Application No: EP/35/22/HH
Site Address: West House South Strand East Preston BN16 1PN
Description of works: Erection of single storey front extension, first floor front/side extension and alterations to fenestration/openings.

Thank you for your internet representation made on 17th May 2022 which has been recorded as an objection with the comments as follows:

E ELEV

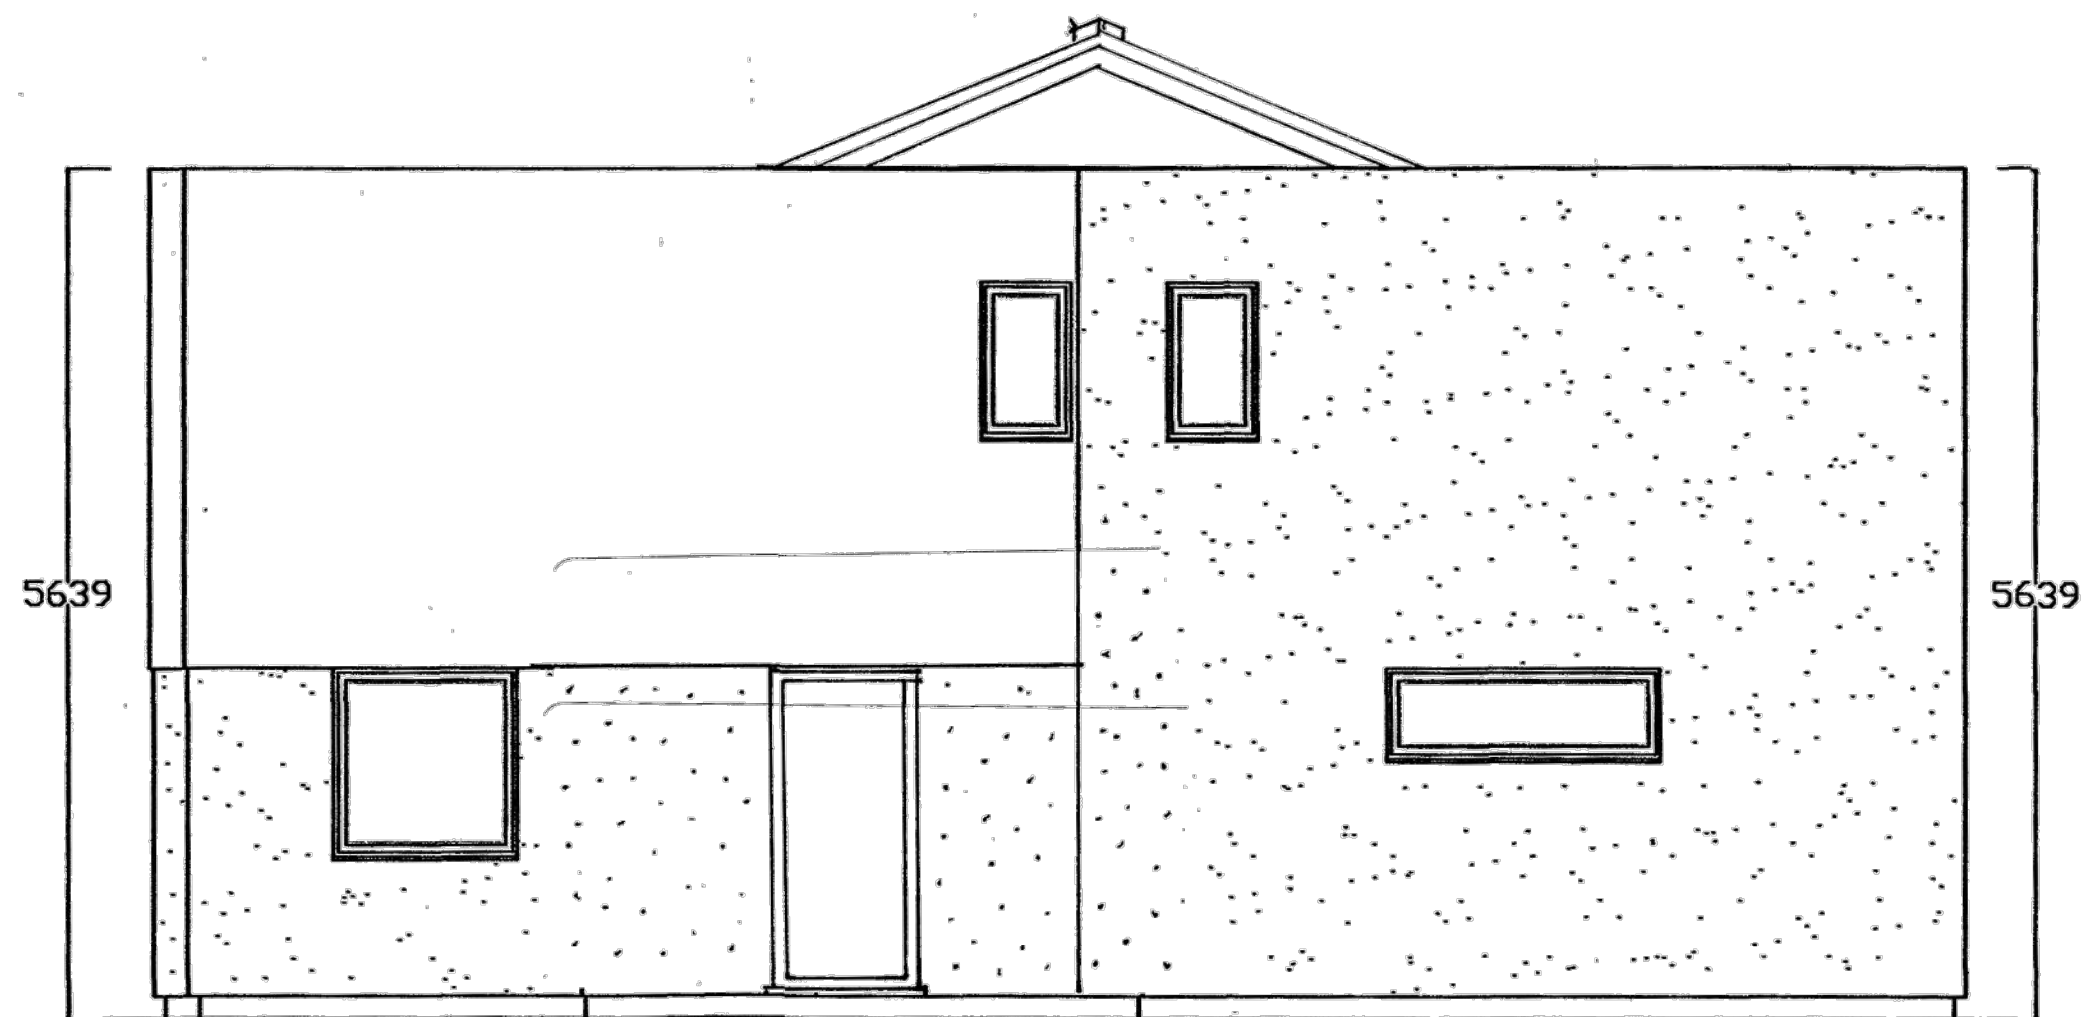
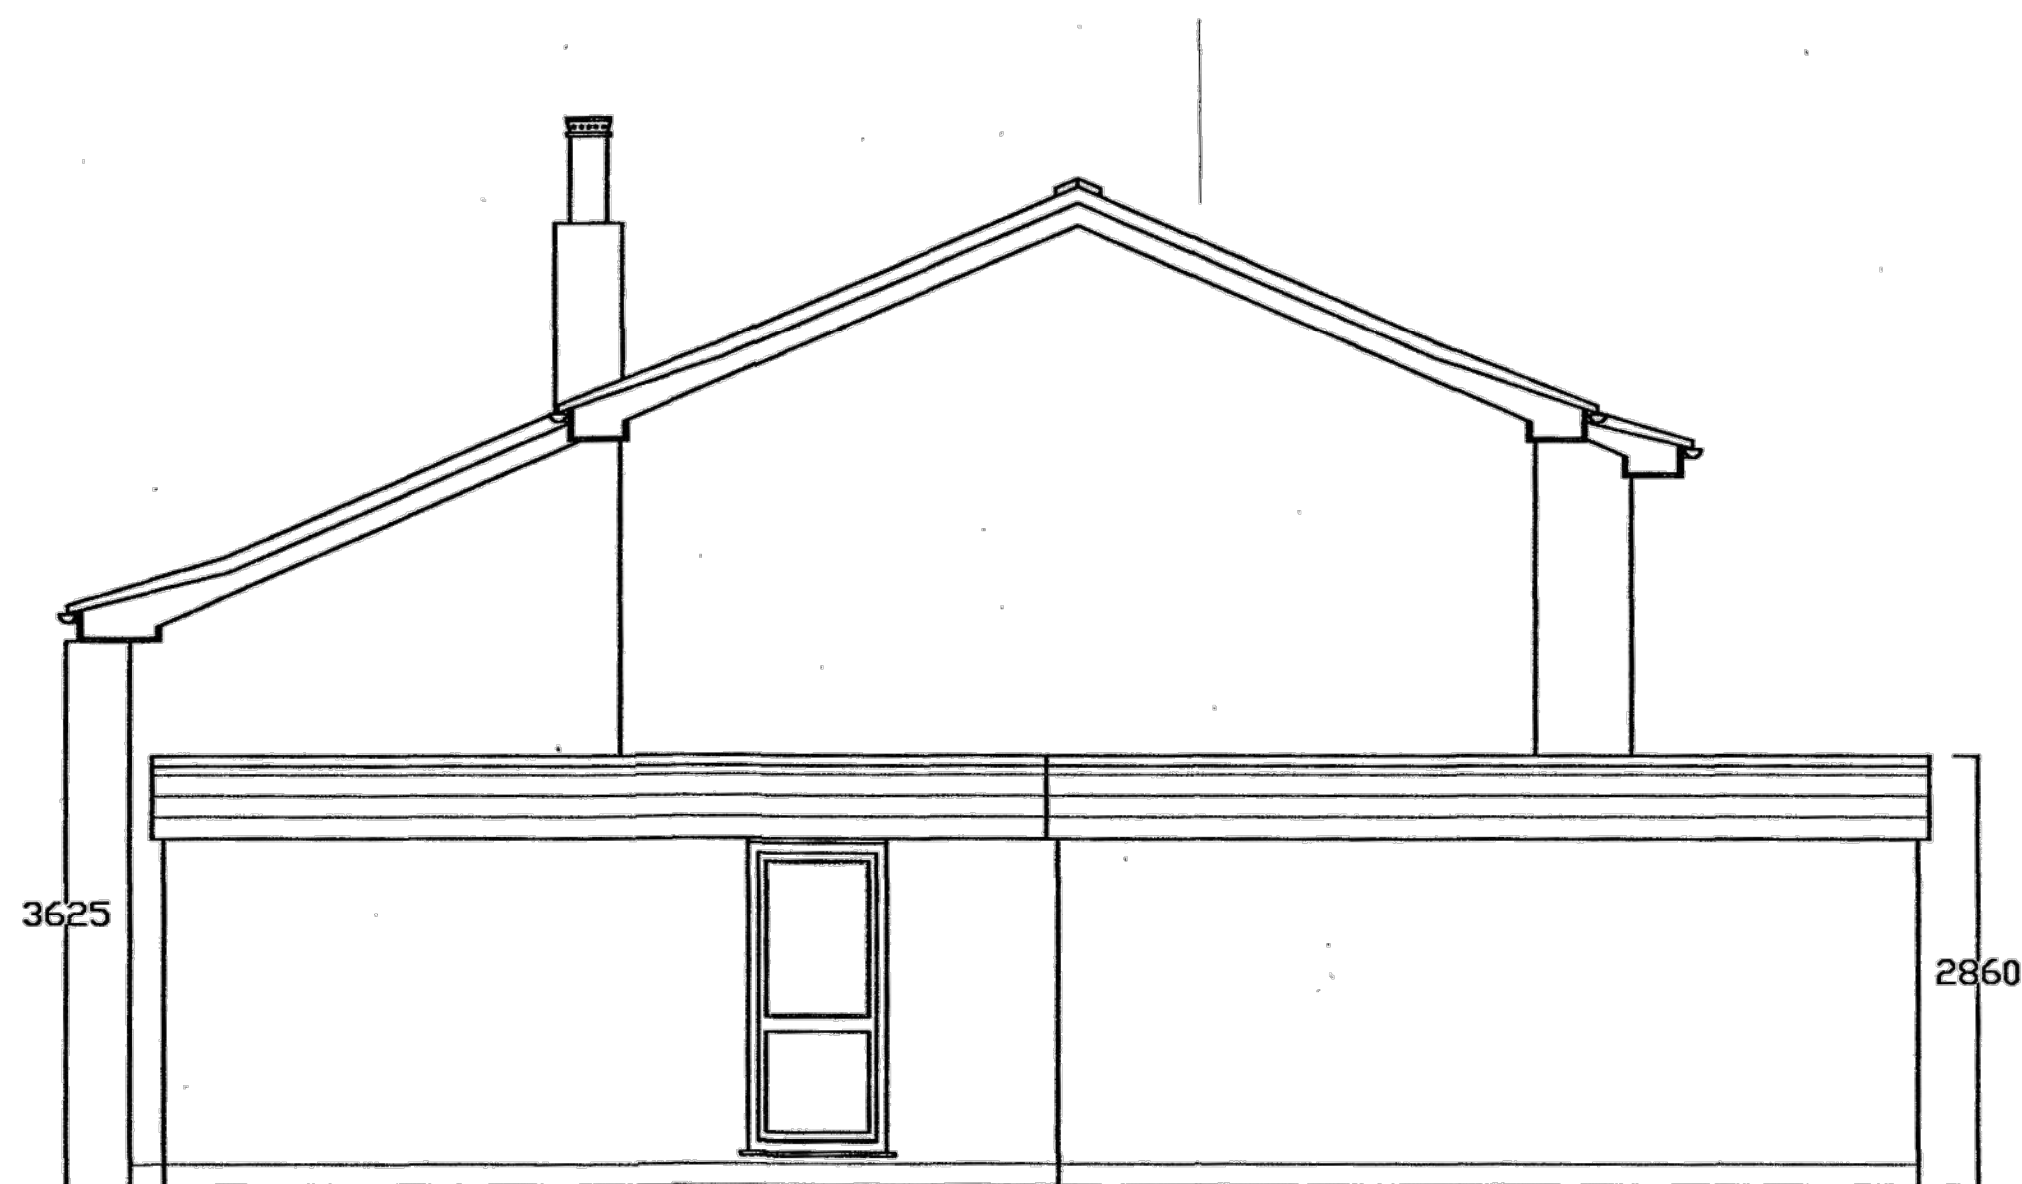
1. Fully screened balcony in opaque glass 1.7 meters high including returning into the pitched roof on the east elevation.
2. All new glazed windows/panels in the south elevation should be opaque and fixed shut.

S ELEV

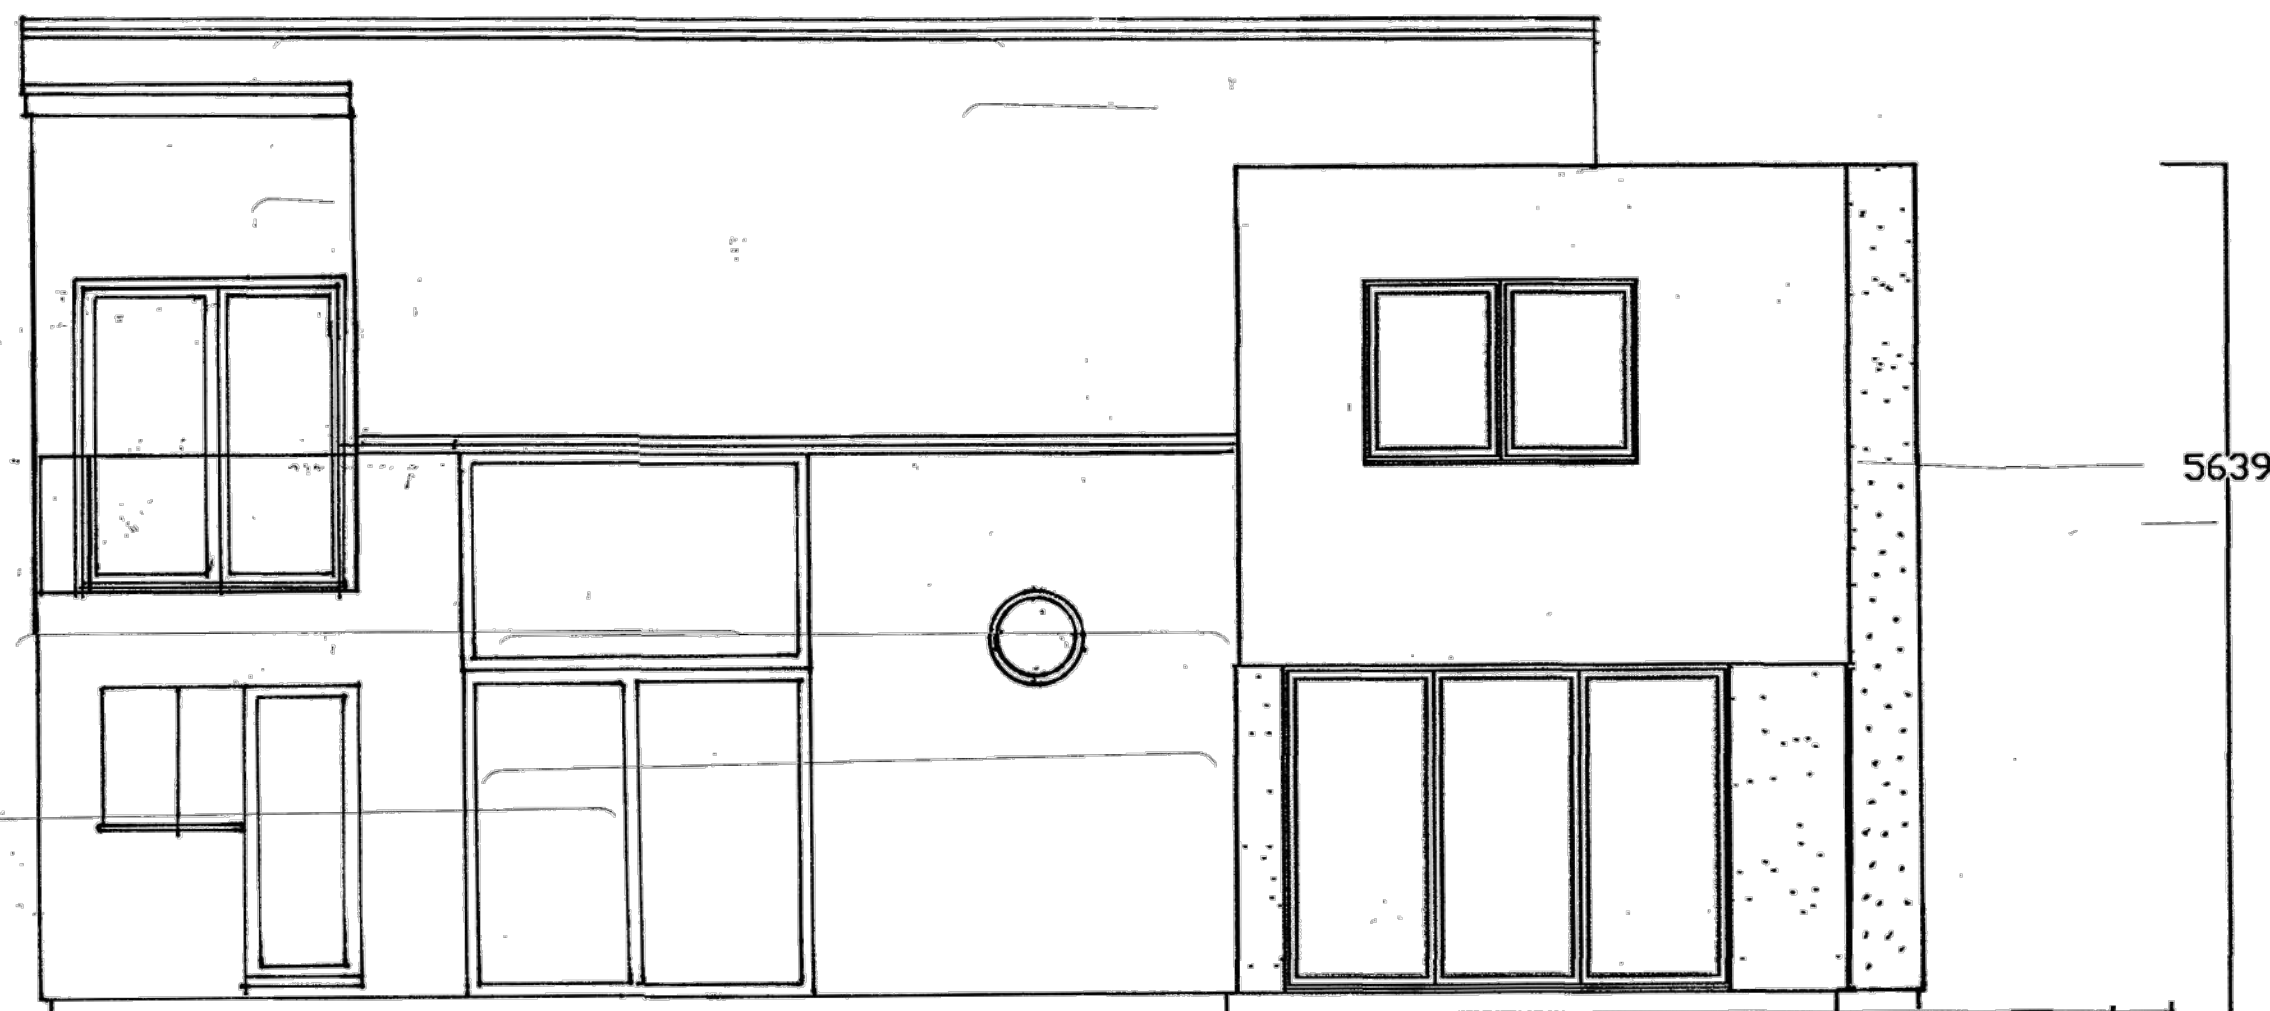
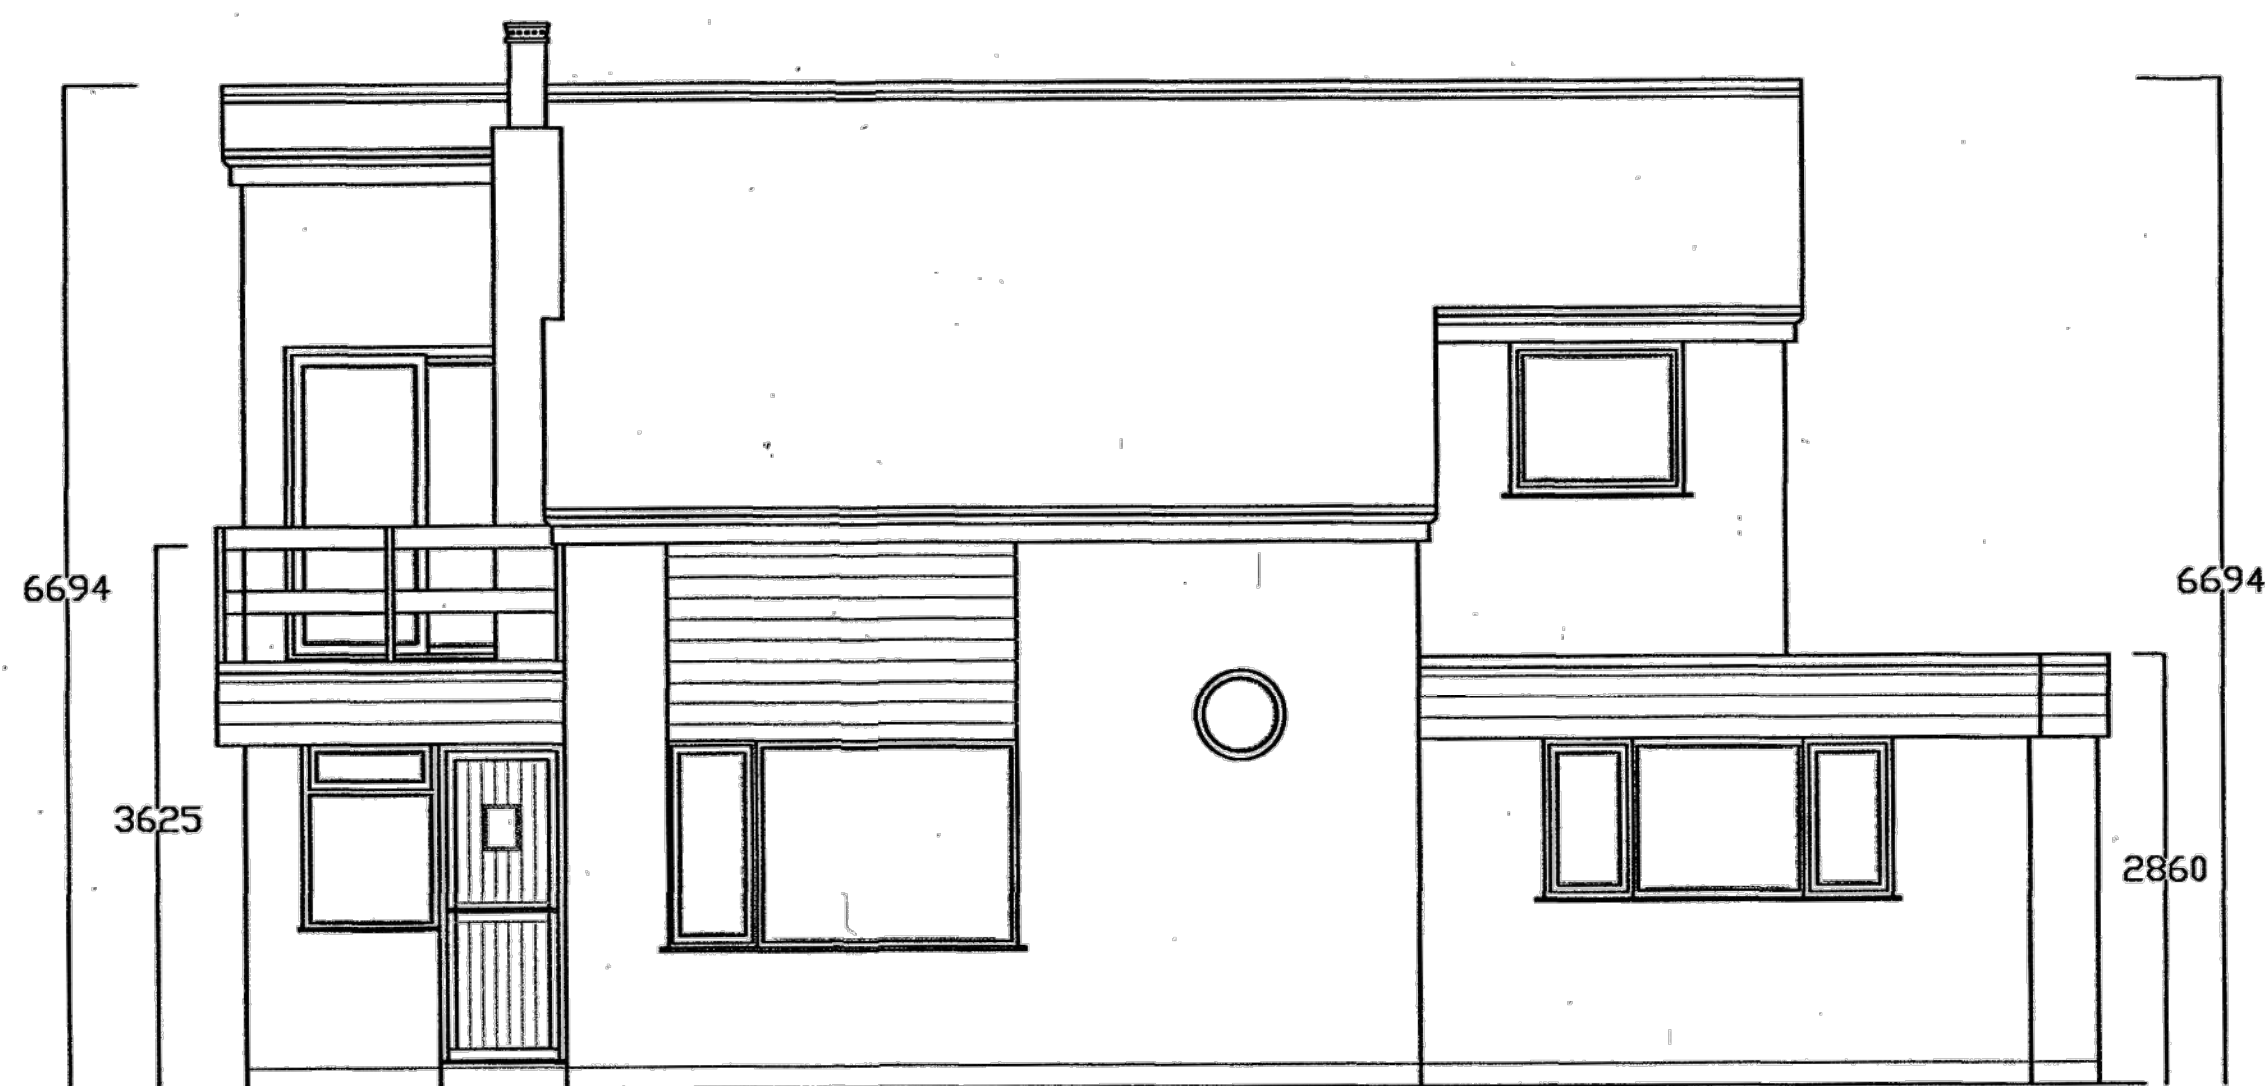
- On the south elevations the proposed bedroom window will look directly into Dolphins East and Dolphins West.

- The proposed glass panel above the door, will also look directly into Dolphins East and Dolphins West, especially when standing in West House on the upstairs landing.
